APPLICATION FOR: 35700/APP/2014/1220

22 BROADWATER GARDENS HAREFIELD

Item No. Report of the Head of Planning, Building Control, Sport & Green Spaces

Development: Change of use from Use Class C4 (HMO) to Sui Generis to increase occupancy in HMO from 6 to 8 persons

Drawing Title
GARDEN LANDSCAPING DETAIL

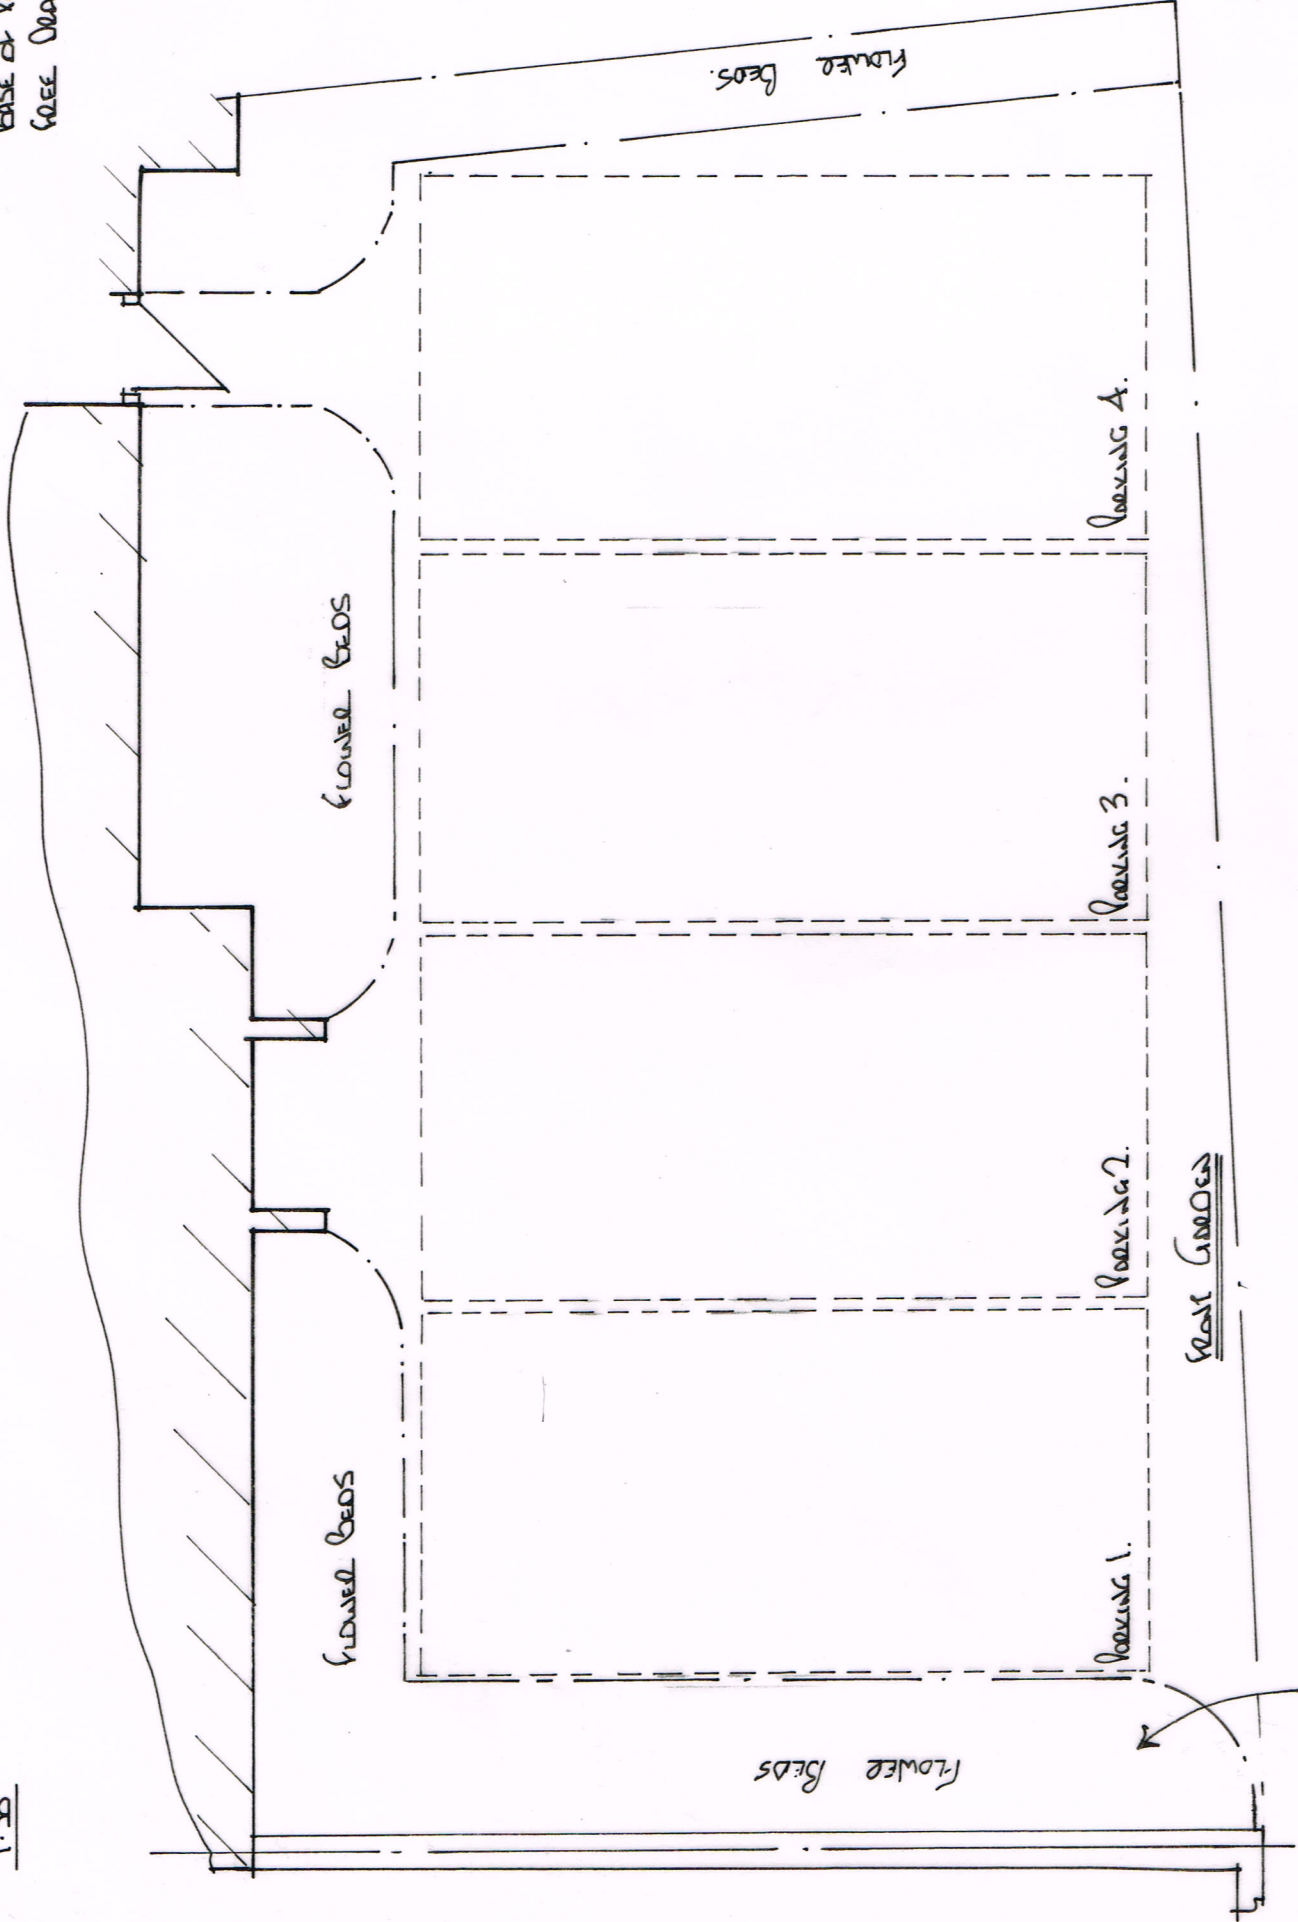
- no trees or other landscape features of merit will be affected by the proposal;
- the retention of the four parking spaces and total hard landscape within the front garden to accommodate four parked cars is currently detrimental to the character and appearance of this residential area;
- the current arrangement is contrary to Hillingdon's design guidance, which seeks to retain a reasonable proportion (25%) of soft landscape within front gardens;
- this application seeks to increase the occupancy within the building, which is likely to increase the pressure on parking space;
- if recommended for approval, landscape conditions should be imposed to ensure that the proposals preserve and enhance the character and local distinctiveness of the surrounding natural and built environment. This will require the removal of at least one of the parking spaces.

Amended site layout landscaping plan (23.9.2014) - additional information requested to specify plant species, numbers/densities, height etc.

In order to enhance the character of the surrounding and meet this criteria, more landscaping would need to be provided, preferably without the need to remove any of the parking spaces which given the increased occupancy of the dwelling proposed, would inevitably lead to pressure on local street parking.

In this regard, the applicant was requested to provide suitable layout plans to indicate a minimum of 25% landscaping to the front of the building, with the four car parking spaces shown to be retained. It was suggested that planting and landscaping areas should include borders and as much of the frontage as possible. The inclusion of plants or shrubs of such a height that may obstruct driver visibility when reversing out would clearly be impractical but the landscaping should take the form of permanent soft low level planting areas.

Revised landscaping plan (received 15.10.2014) - considers acceptable. Plants will need to be established and maintained by the landlord / management company. Details of the maintenance operations and management should be conditioned as per RES9 (part 4).

Accordingly, the proposal has been amended to indicate a revised site layout to the front of the dwelling with soft landscaping and planting features to be introduced in the only practicable areas for doing so, which are alongside the two side boundaries and adjacent to the front of the building.
